A30 Chiverton to Carland Cross TR010026

8.13 RESPONSE TO HEARING ACTION POINTS - ISH 3 ON WCH

- 1.1.1 This document sets out the Highways England (the Applicant) response to the Hearing Action Points arising from the Issue Specific Hearing into walking, cycling and horse riding for the A30 Chiverton to Carland Cross scheme, which took place at the Old Bakery Studios in Truro at 10am on Thursday 4 April 2019.

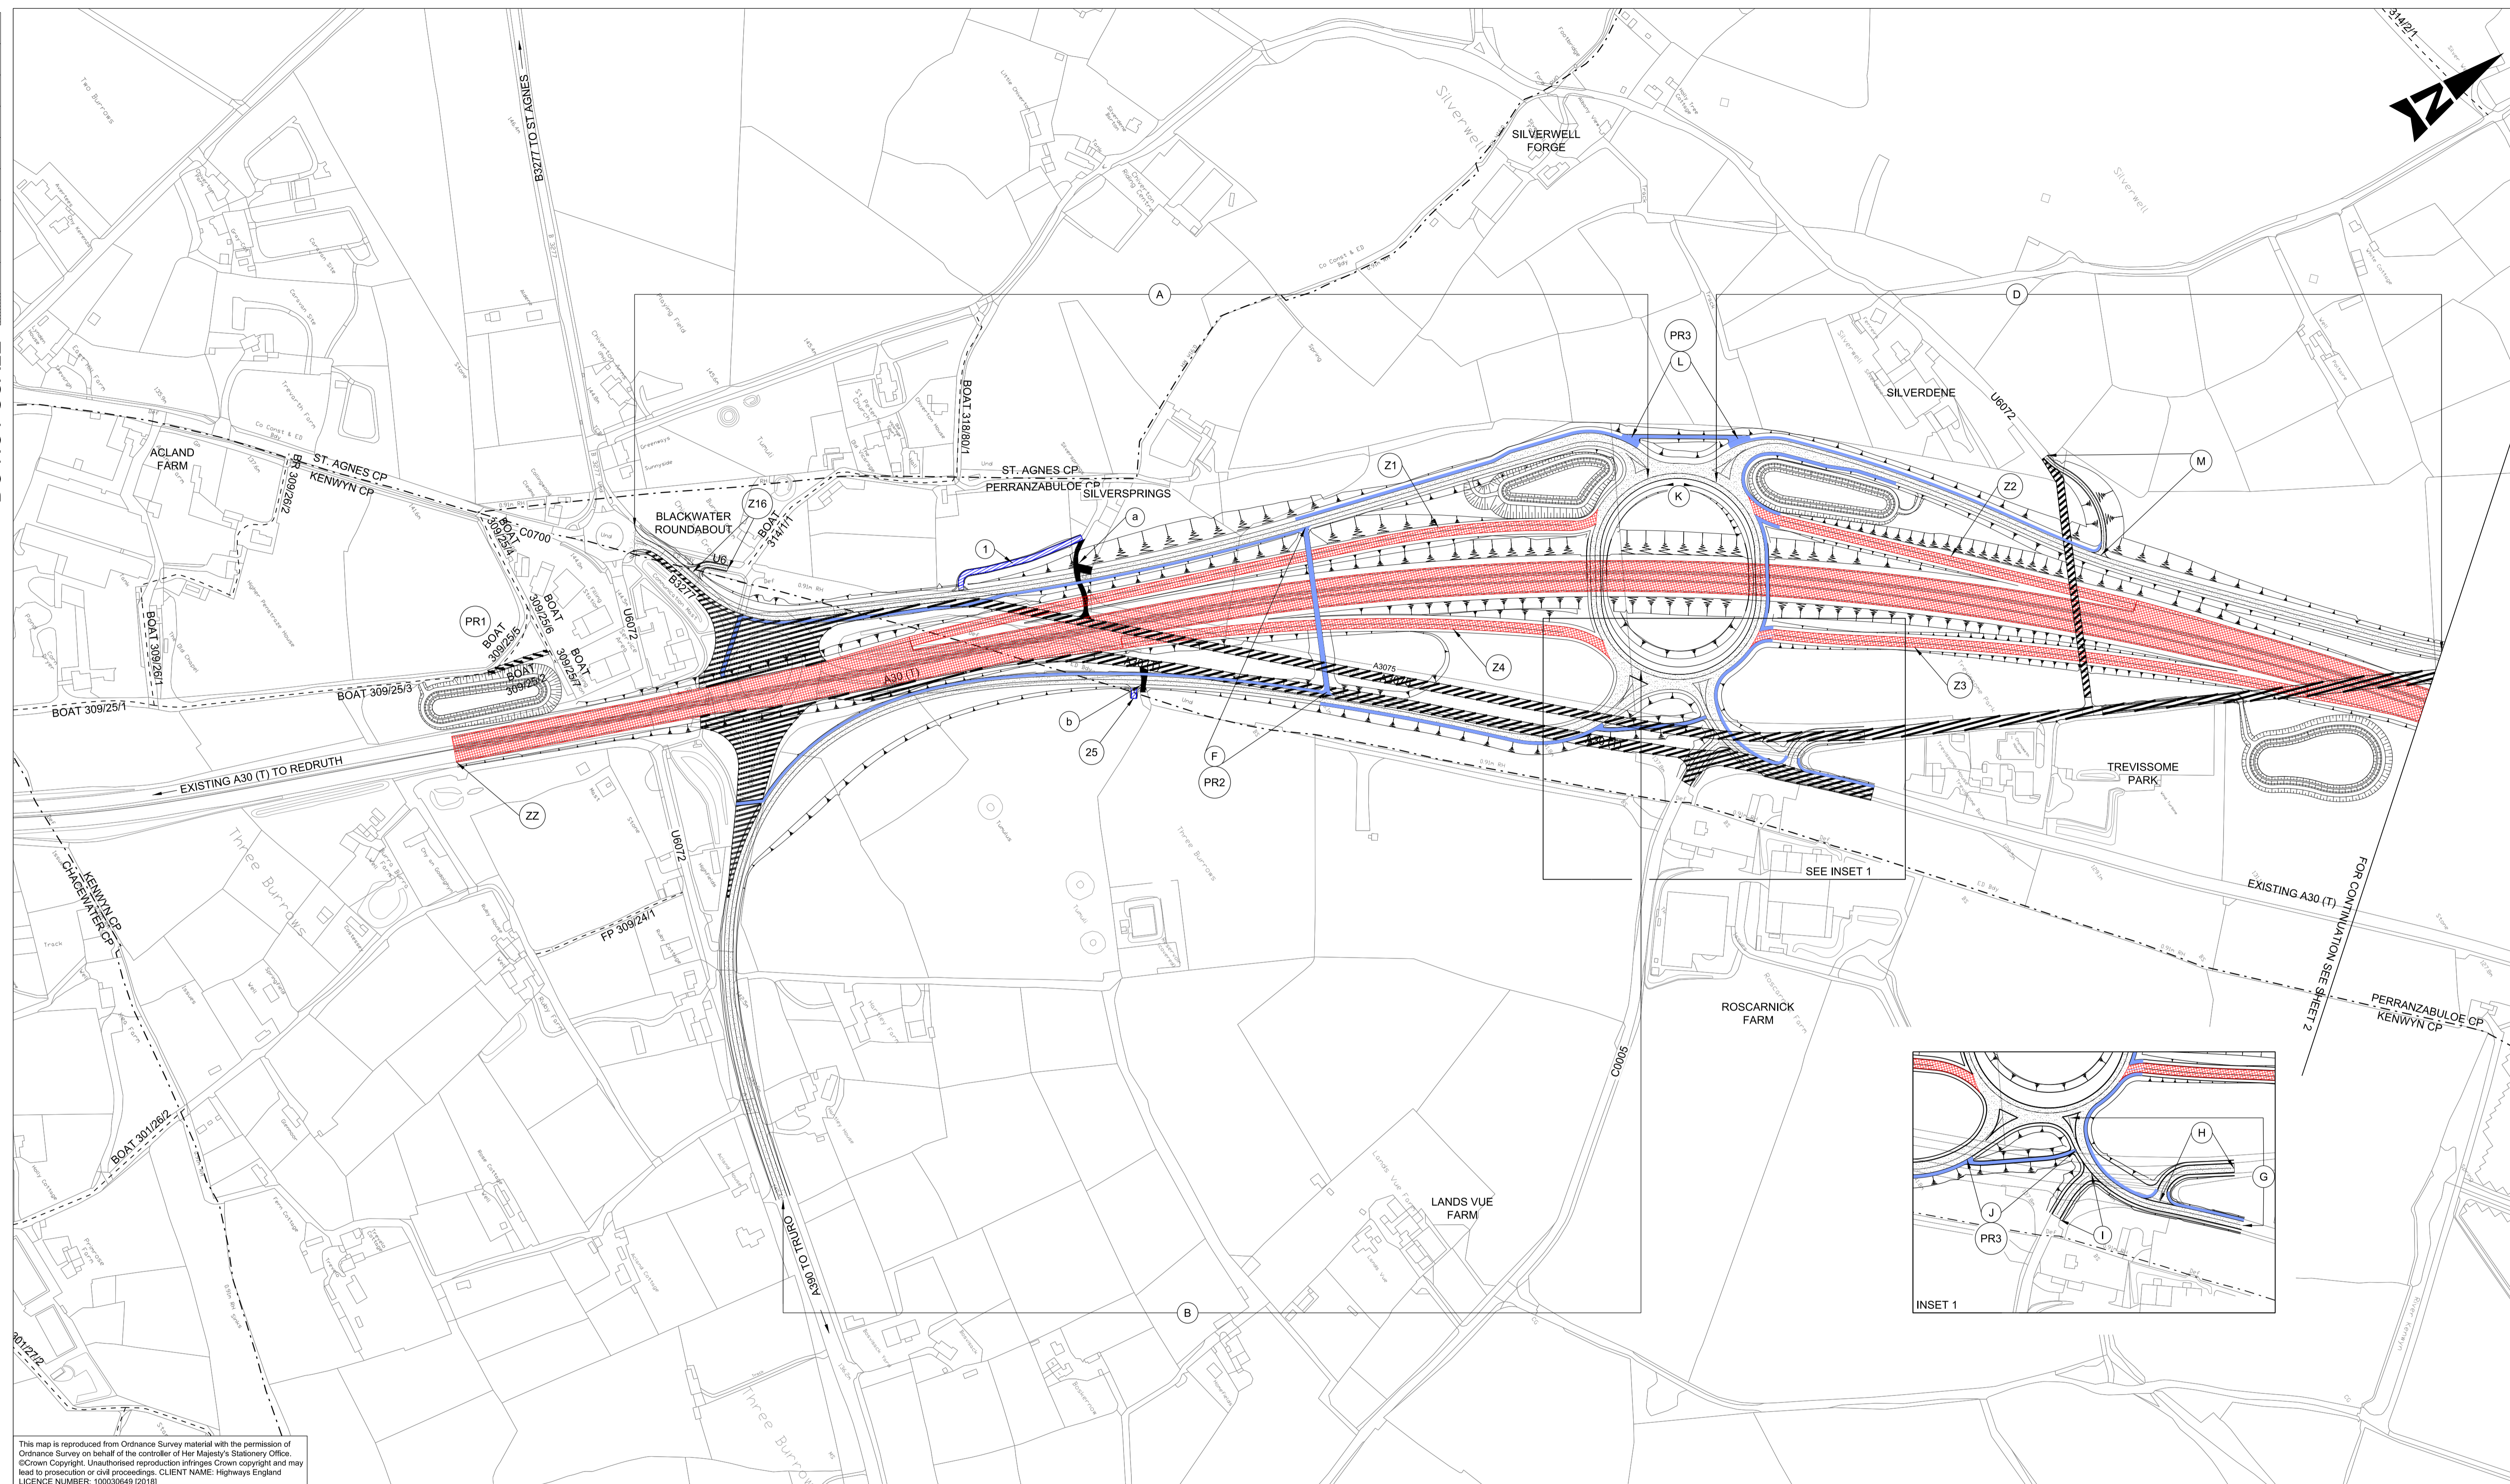
Hearing Action Point 1: Clarification of position regarding potential link west from the existing Chiverton roundabout area to existing BOAT 309/25/7

- 2.1.5 Stakeholders have asked for a further connection to be considered, joining the proposed link with the existing BOAT 309/25/7, in order to provide a convenient east-west route joining the proposed Chiverton roundabout with the existing BOAT network to the west (running parallel and later joining the existing A30 to Redruth).

- 2.1.6 Such a further connection between the proposed link and the existing BOAT 309/25/7 could be provided by constructing a new route for cyclists along the proposed northern verge at the western end of the proposed Chiverton roundabout.

- 2.1.7 Whilst feasible in design terms, there are significant concerns that such a connection would lead to a number of safety issues by facilitating the movement of cyclists travelling westbound along the eastbound verge of the A30.

- 2.1.9 A safer alternative would be available with the proposed A30 scheme in place, where cyclists travelling eastbound on the A30 or westbound on the B3277 from the new junction, could use the Blackwater roundabout and any combination of existing BOATs (refs 309/25/4; 309/25/6; 309/25/5) to make the movement east-west. Although this would be slightly longer than the suggested connection, the Applicant's view is that it would be safer.
- 2.1.10 For these reasons the Applicant does not intend to add the suggested connection.

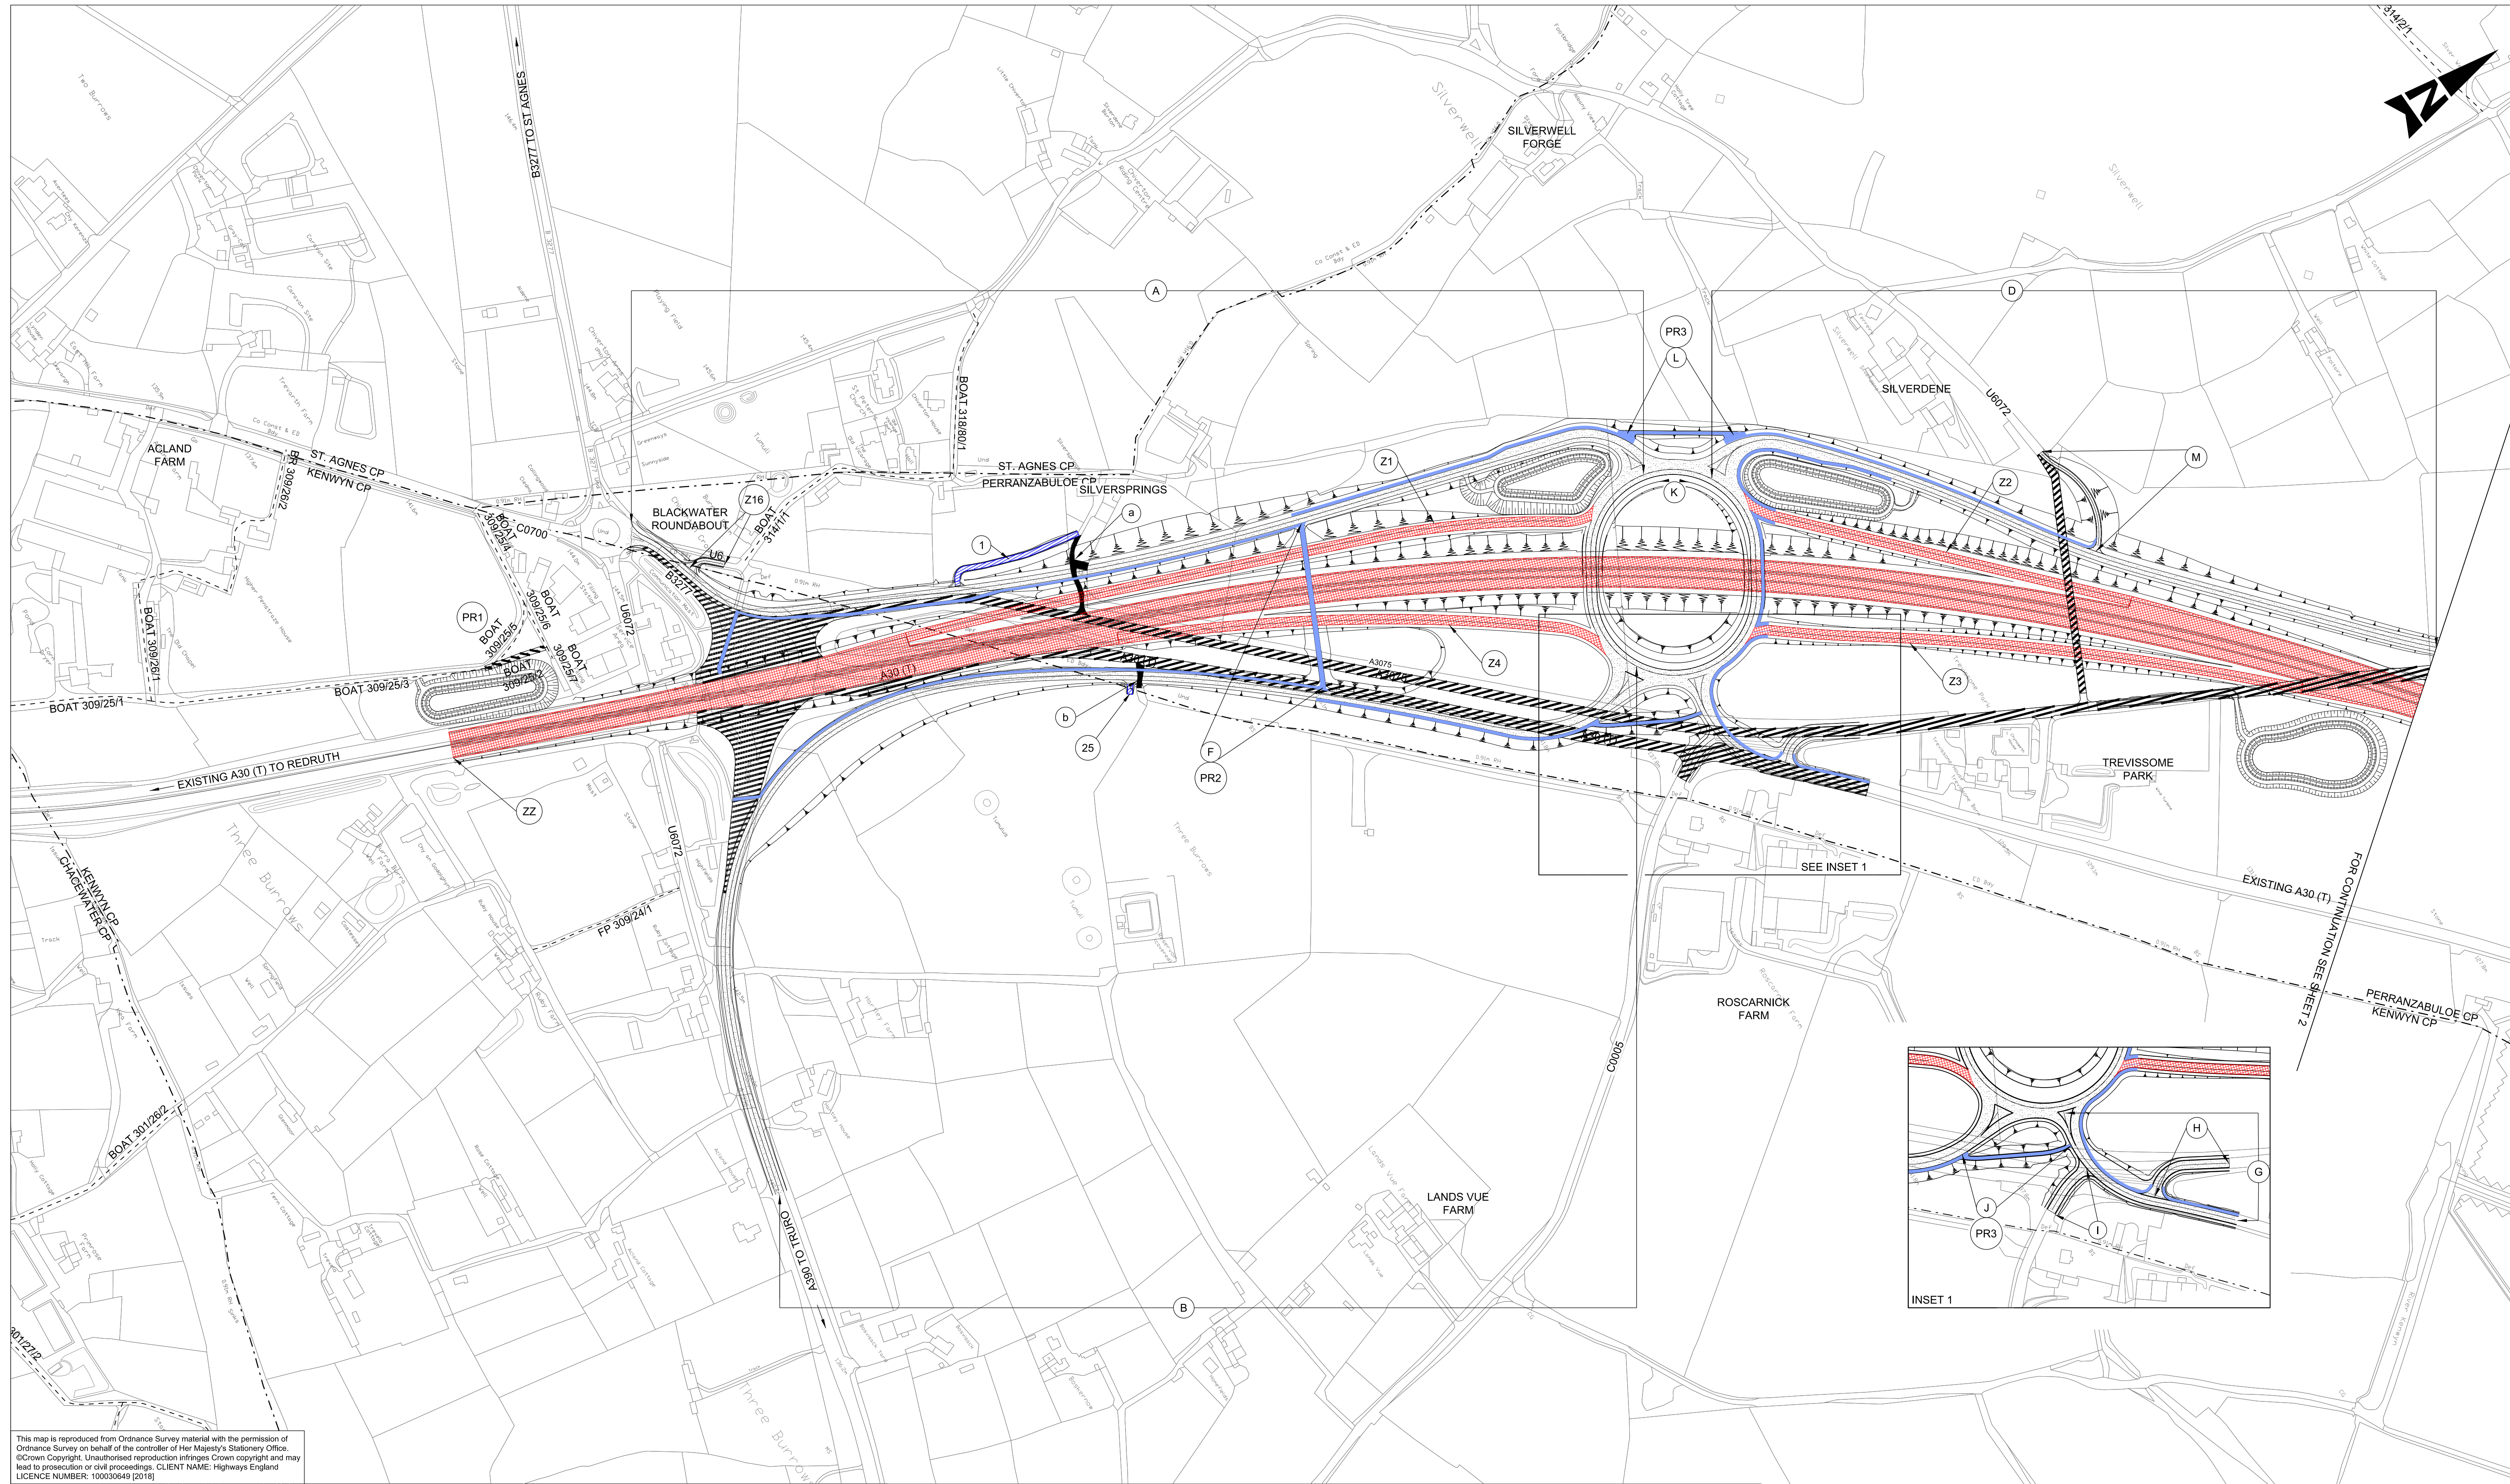
Hearing Action Point 2: Clarification of position regarding potential higher rights link in the area shown on Rights of Way and Access Plans Sheet 3-ref. Z (PR5)

- 3.1.6 In order for cyclists to utilise the footpath (ref PR5), cyclists could dismount and carry their cycles up or down the steps. The ISH heard from stakeholders that an alternative arrangement to help facilitate the convenient movement of cycles should be considered by Highways England e.g. stepped access as proposed but with an adjacent or alternative ramped access.

- 3.1.7 Given the gradient of the proposed embankment at the point of the proposed footpath (ref PR5), a full standard cycling ramp with landings would require significant length and cost which the usage could not justify. However, it would be feasible to provide a sloped parallel path adjacent to and as part of the stepped access to allow cyclists to dismount and wheel their cycles side by side. This would provide a reasonable alternative that is safe for walkers and cyclists.

- 3.1.8 This arrangement is now described in a revised Annex M: Public Rights of Way Management Plan in the **Outline CEMP Annexes** (Document Reference 6.4(A)) and shown on Sheet 3 of the **Rights of Way and Access Plans** (Document Reference 2.5(C)) submitted at Deadline 3. A minor amendment has also been made to Part 2, Schedule 4 to the draft **DCO** (Document Reference 3.1(D)) to confirm the provision of an adjacent sloped path.
